PEMULWUY DEVELOPMENT (Precinct 3) – Design Review Panel Meeting No.6

DATE: 10/04/2017

5.4 Panel Discussion/Recommendations		
5.4.1	The presentations today were a great development since the last meeting.	
5.4.2	DPRM6 to be the final review and the scheme good to submit pending the following suggestions.

Response to Eveleigh Street Context

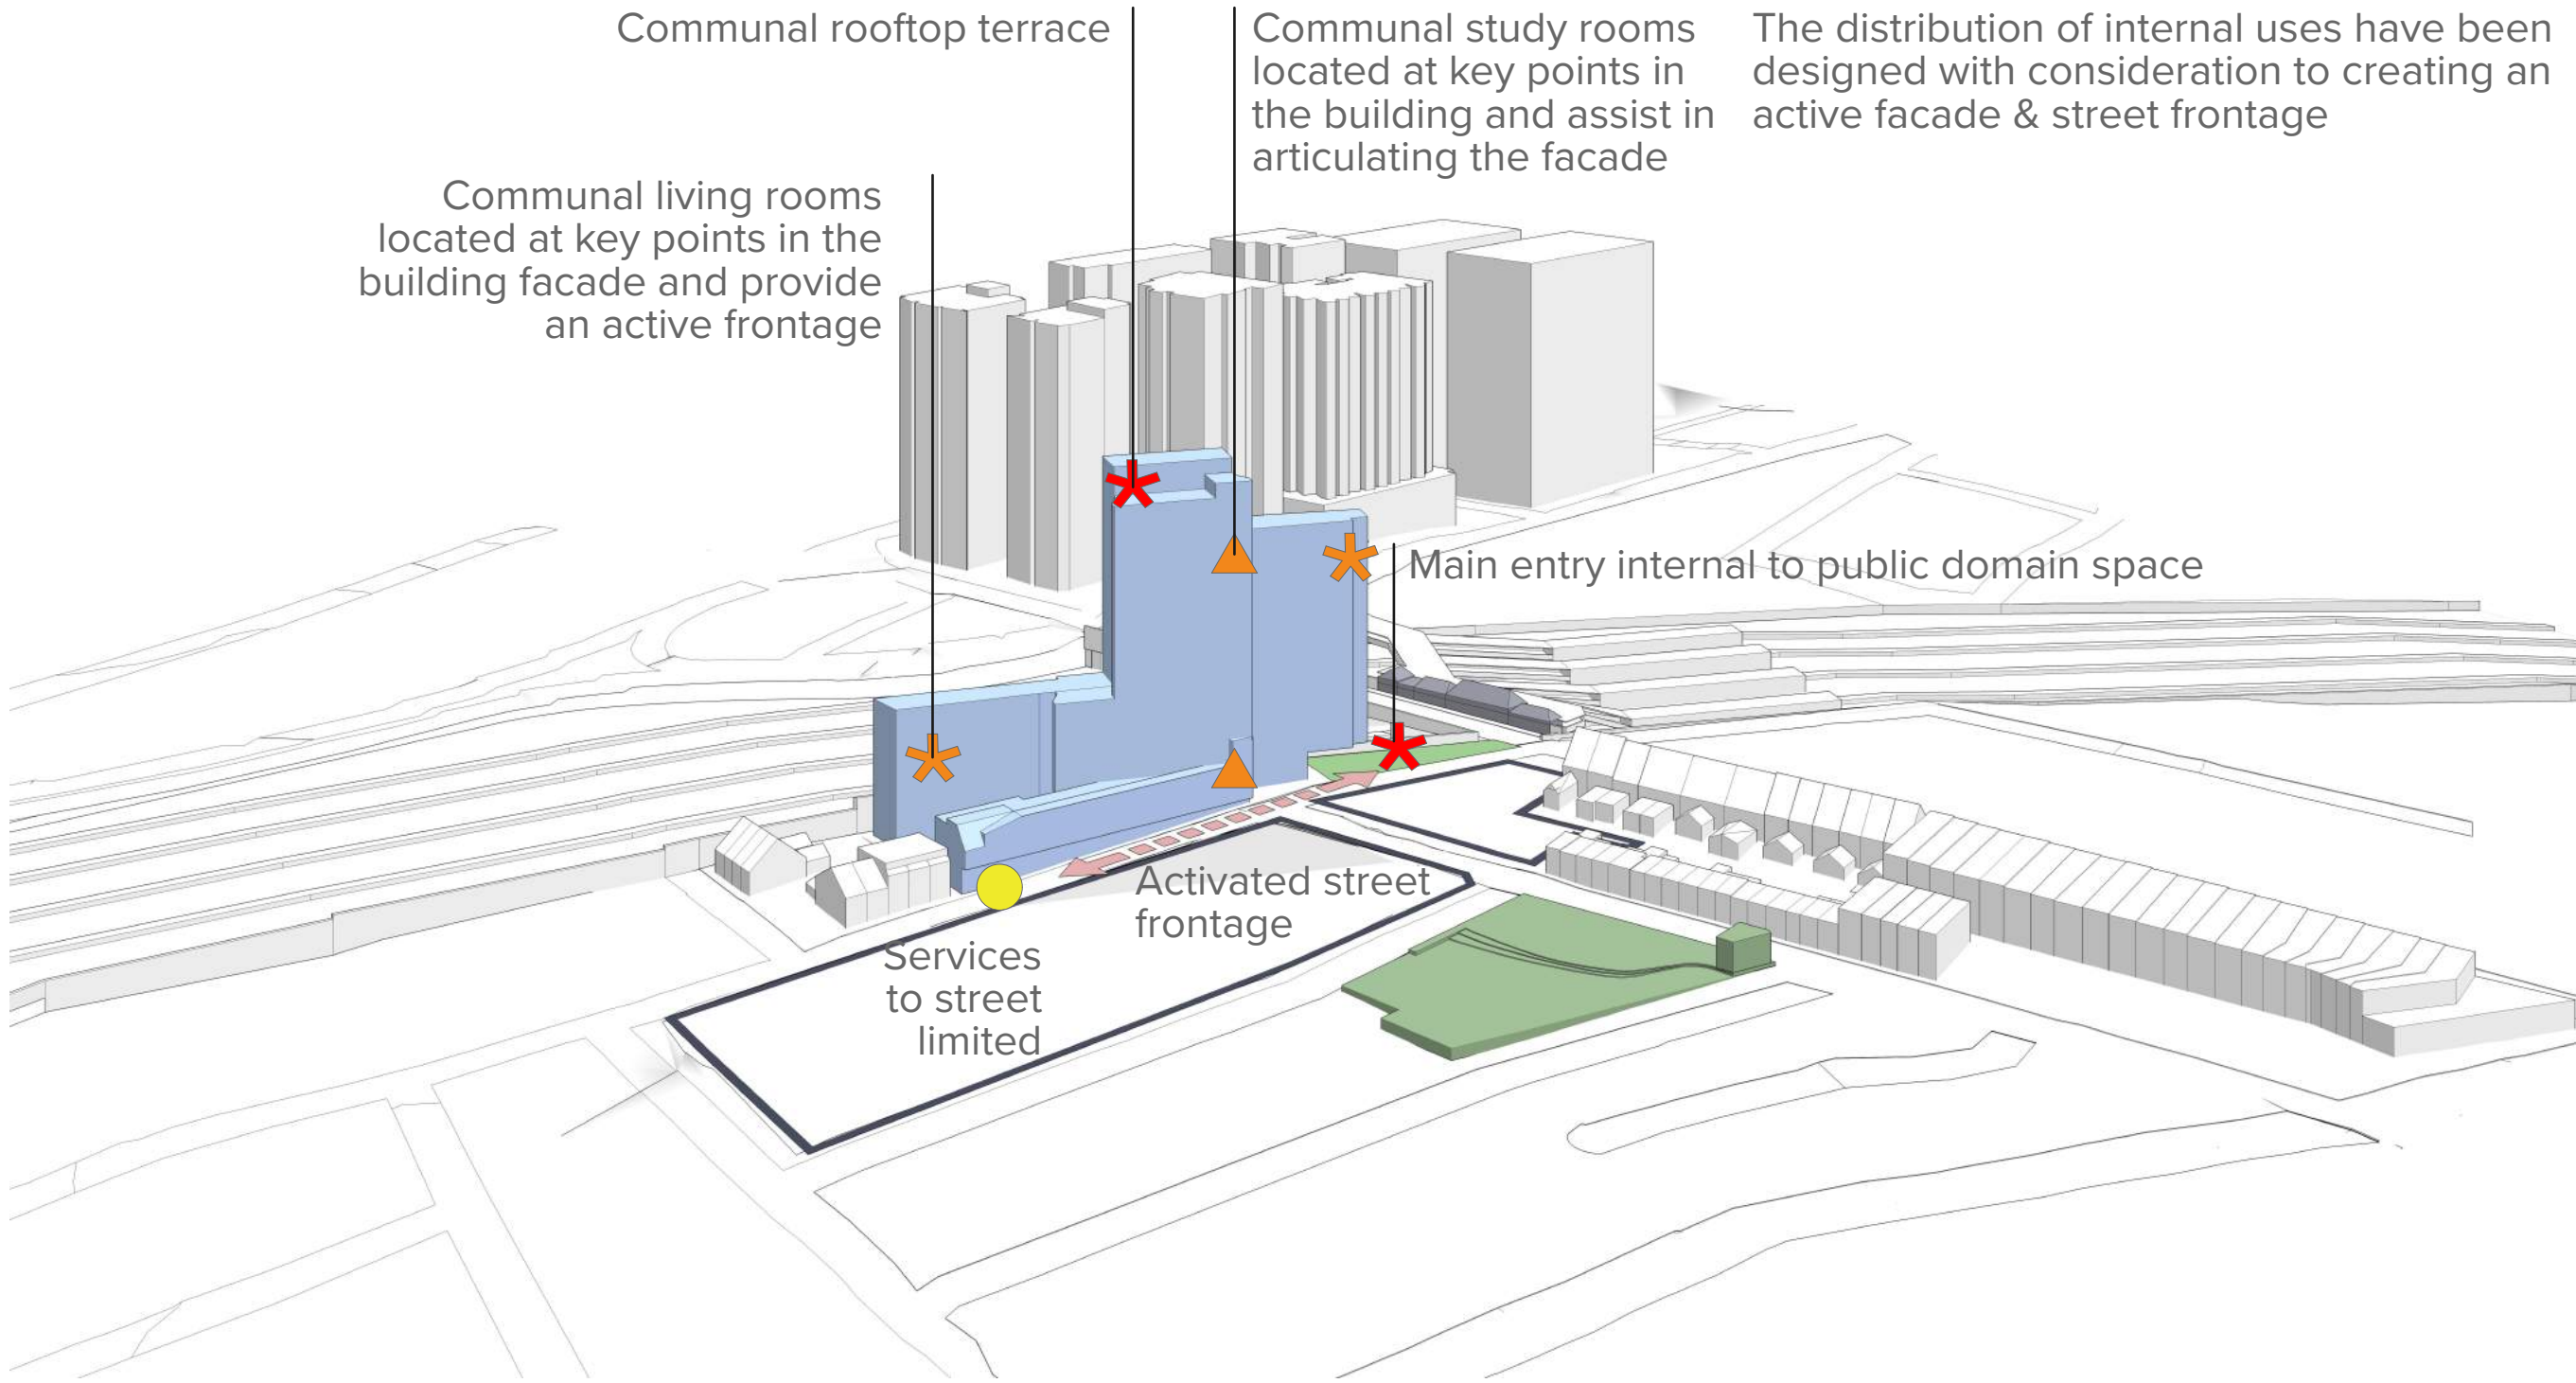
5.4.3	Secondary (student) entry to building. Footpath along Everleigh street is narrow. Provide a pause point at the entry via a recess in the glazing that currently sits flush with the site boundary. Suggest a seat and planting to soften the entry and provide additional footpath circulation space.
